H. B. ZACHRY COMPANY REQUEST FOR INFORMATION ADDISON AIRPORT TUNNEL. Subcontractor (if applicable): RECO. Originator: Majed Lamm. Subject: Modifications of RECO existing wall design to expedite approval. Problem: H. B. Zachry intends to revert to the original design in order to construct the 48" shaft shafts (with no embedded plates) to the present panels. Response by Construction Management: THIS IS NOT THE INTENT OF THE CONTRACT...

FINAL RECORD DRAWING Date: 12/25/99. NORTH TEXAS TOLLWAY AUTHORITY ADDISON AIRPORT TUNNEL. RF# 141 - 155. DRAWN: DATE, CHECKED: DATE, DESIGNED: DATE, SCALE, SHEET OF, CONTRACT NO. DNT-260.

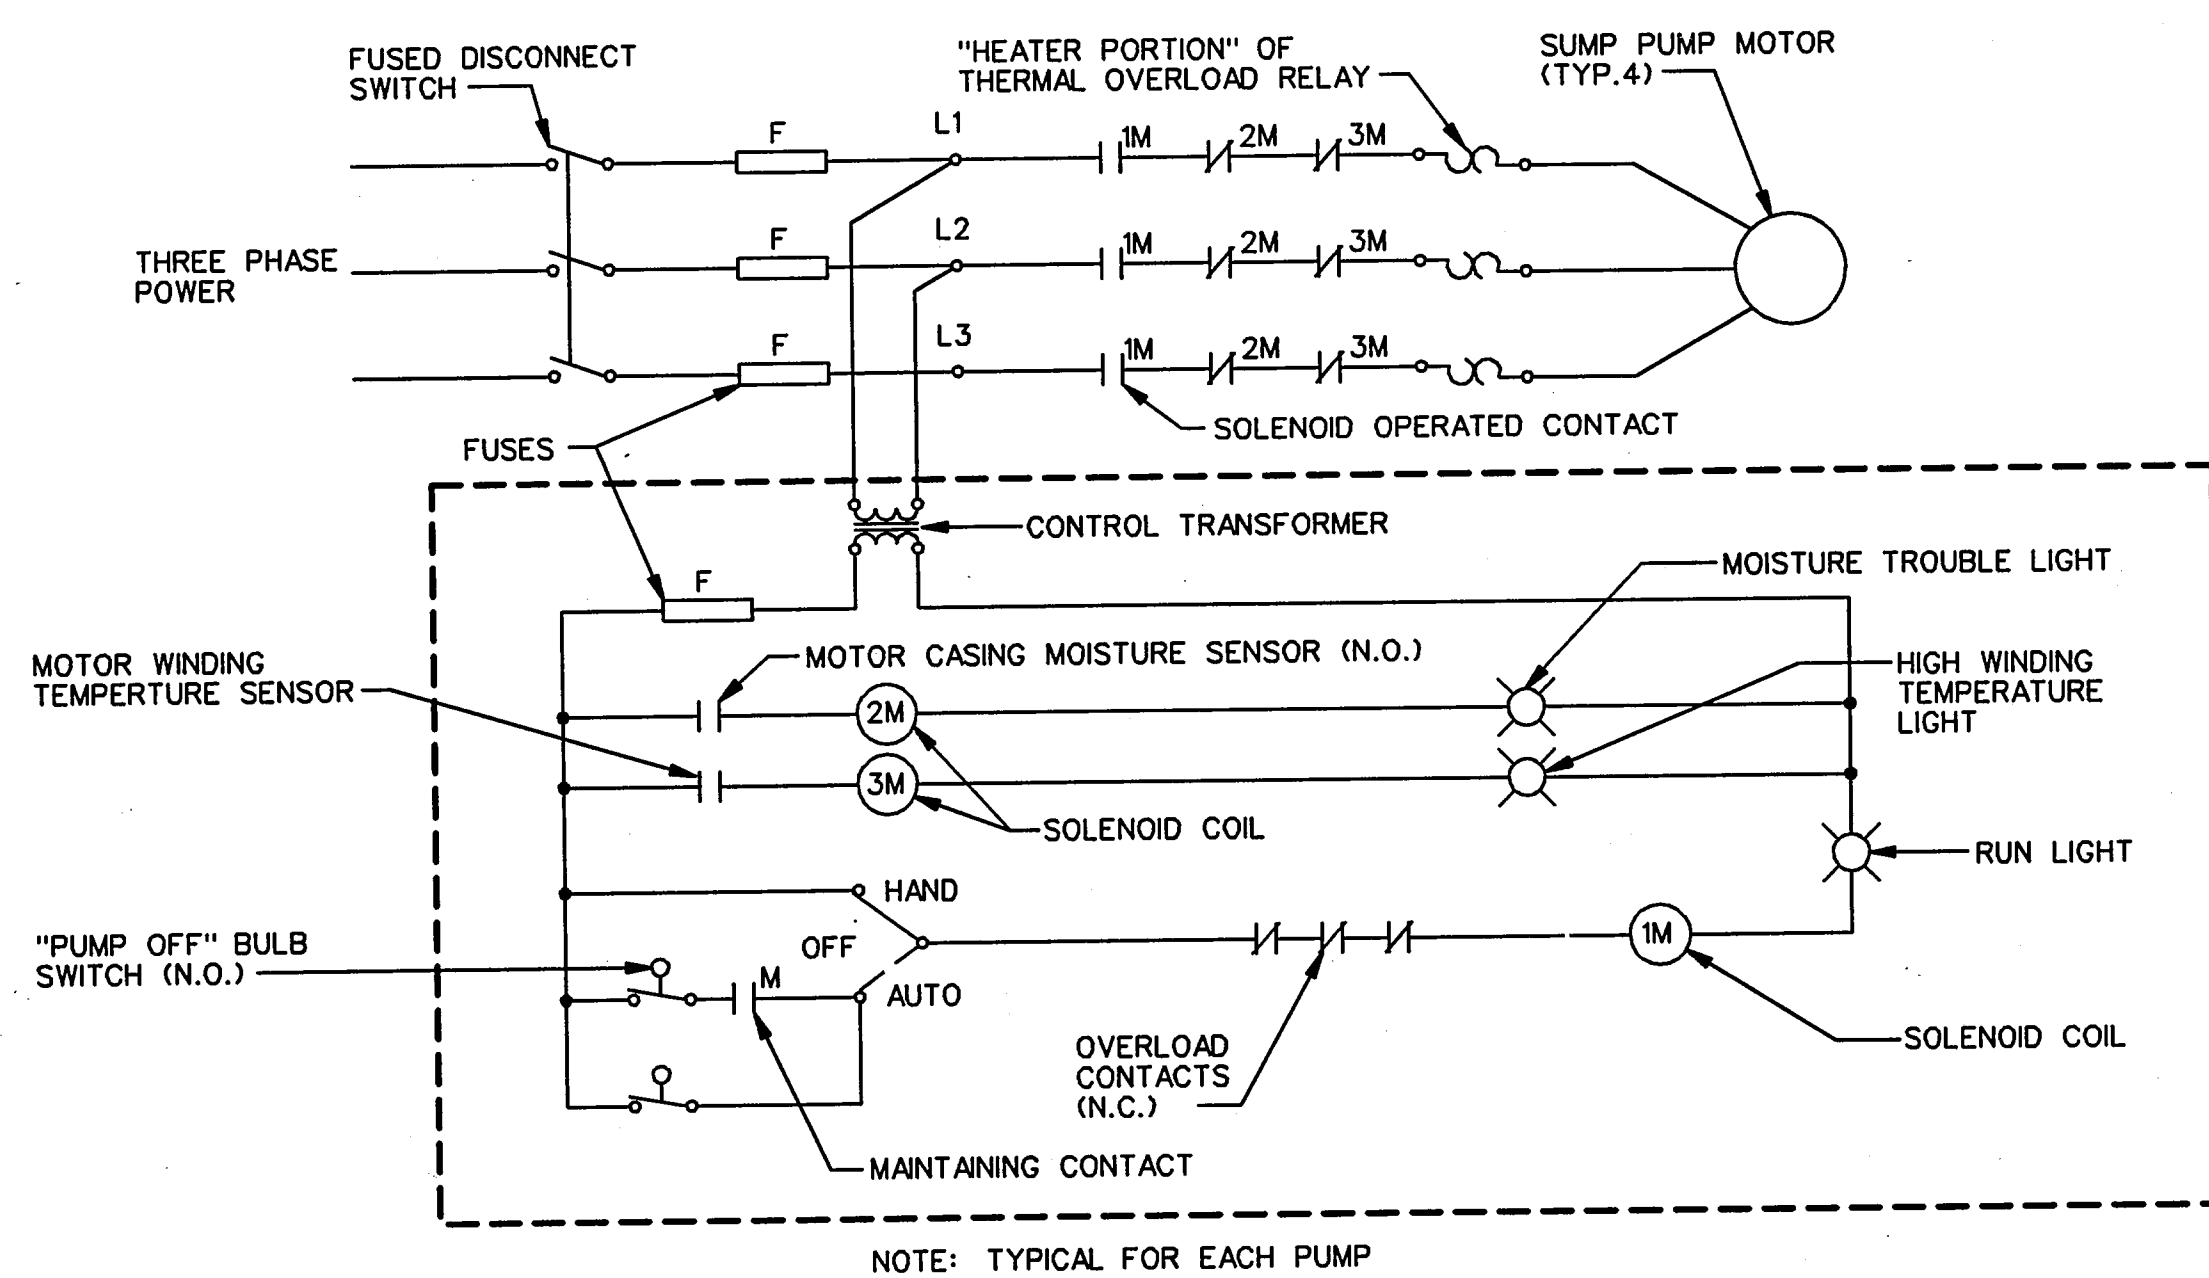
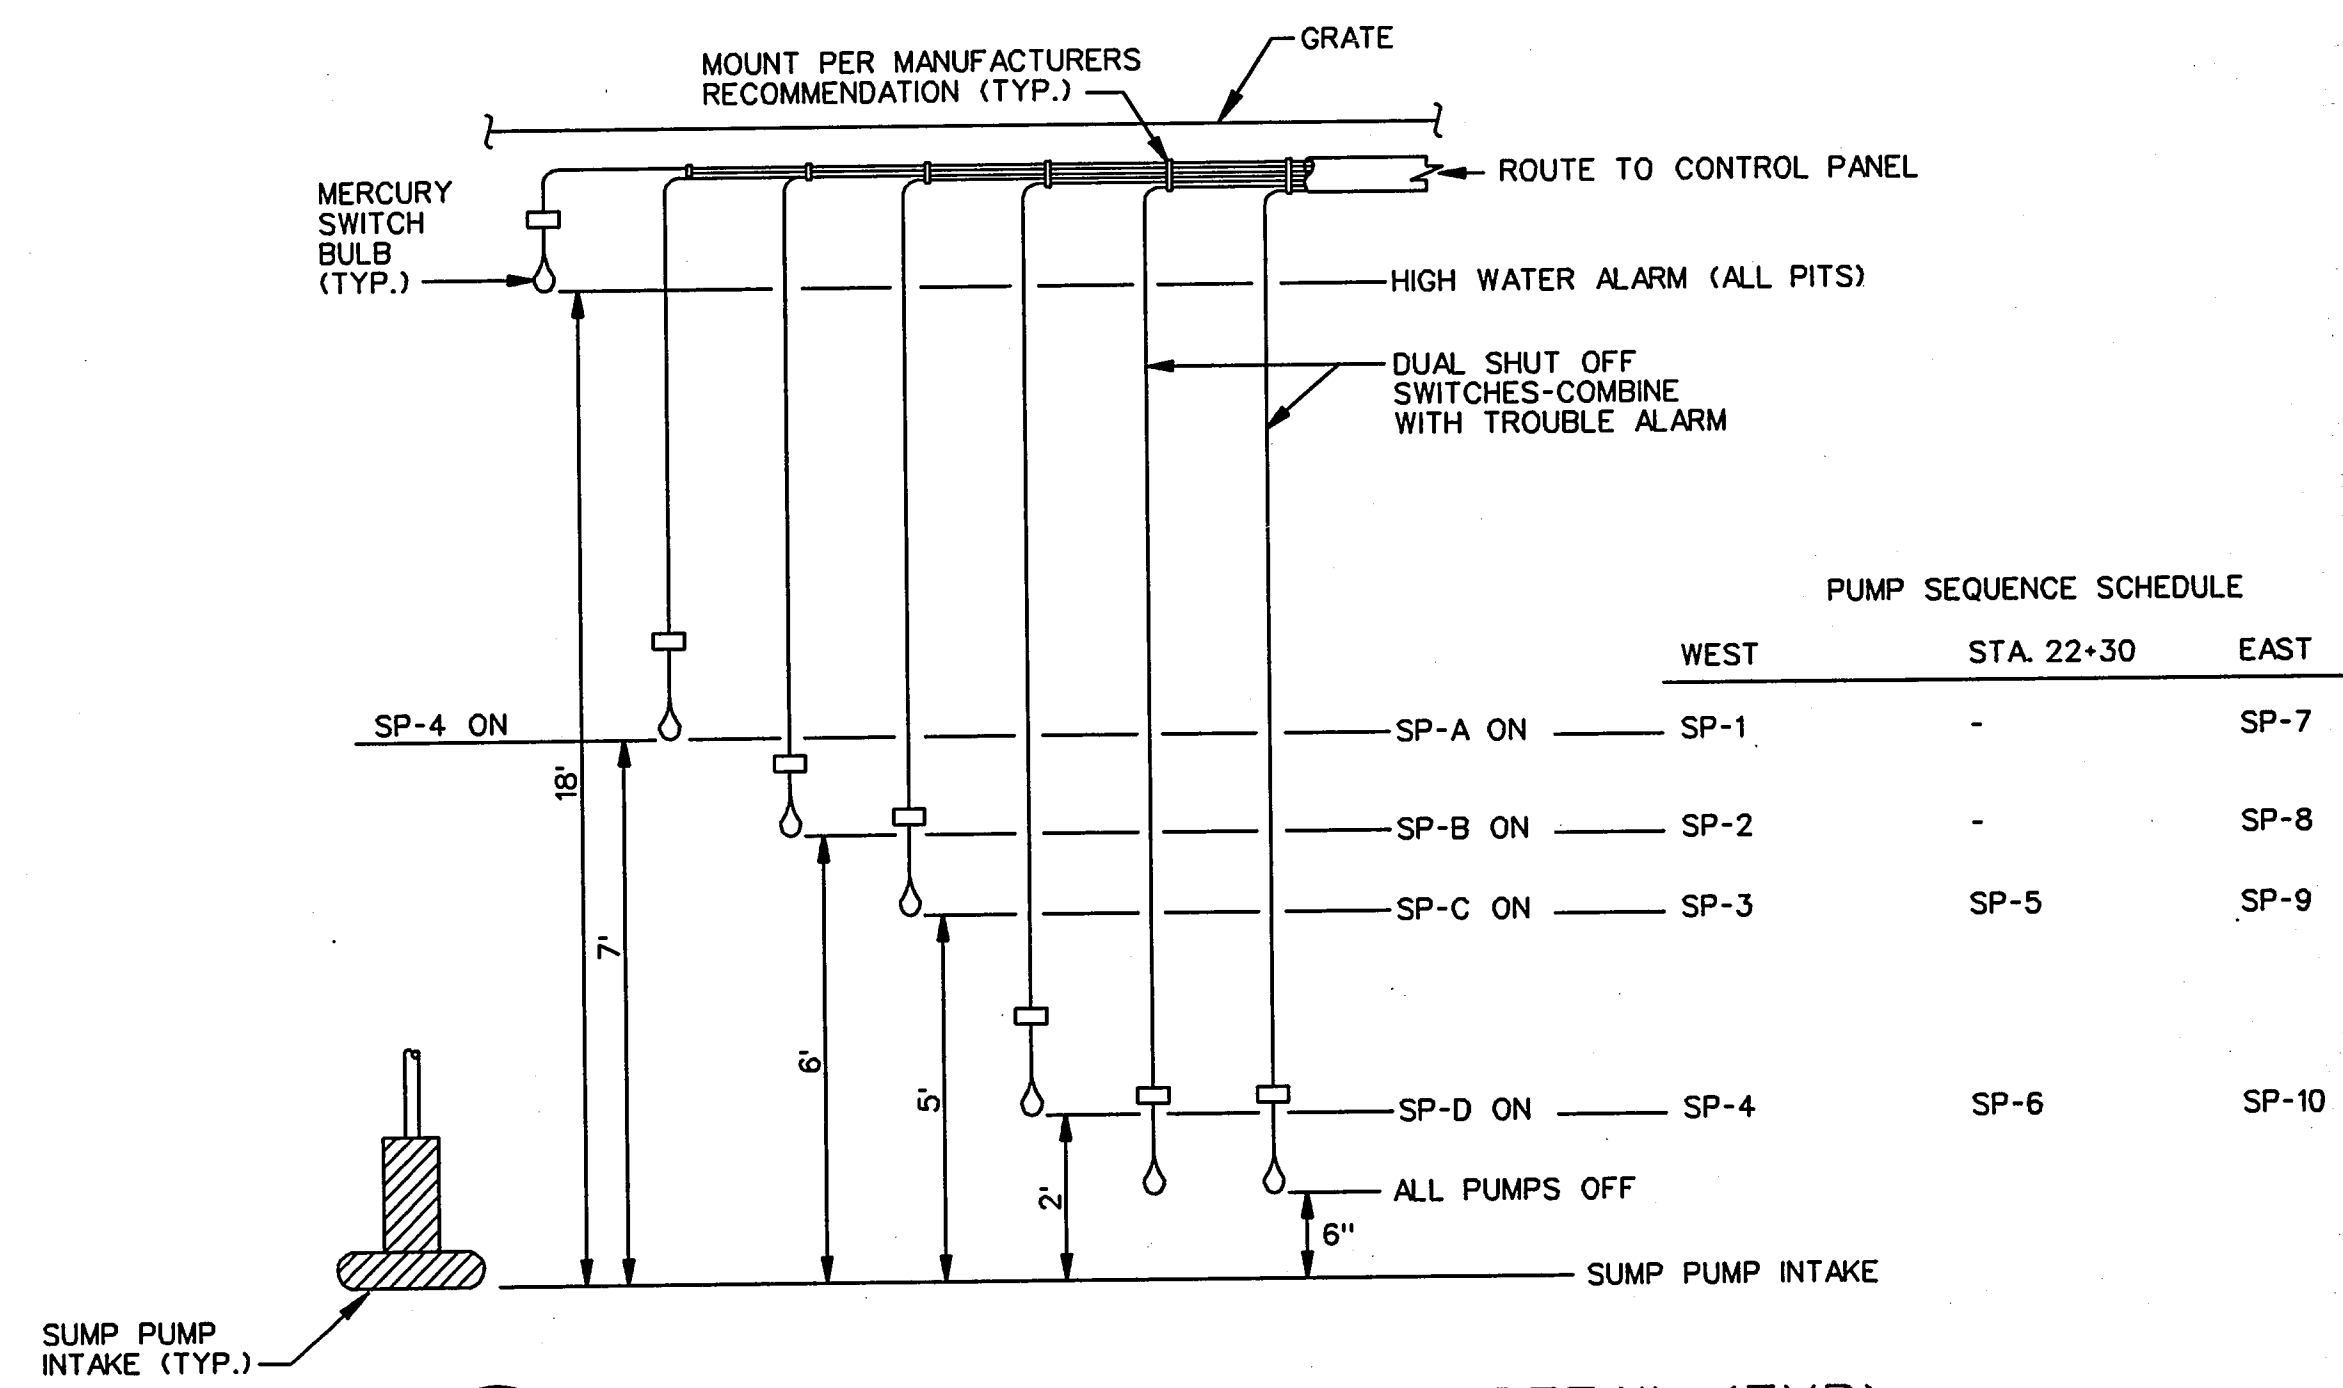
ZACHRY-MONTEREY REQUEST FOR INFORMATION ADDISON AIRPORT TUNNEL - JOB #9080.01. Subcontractor (if applicable): RECO. Originator: Majed Lamm. Subject: Weir Sump Pit. Problem: The above referenced sheets do not provide an elevation for the pumps in the weir pit. Response by Construction Management: THE 30" DIA. DRILL SHAFTS ARE TO BE CONSTRUCTED WITH 12" DIA. DRILL SHAFTS...
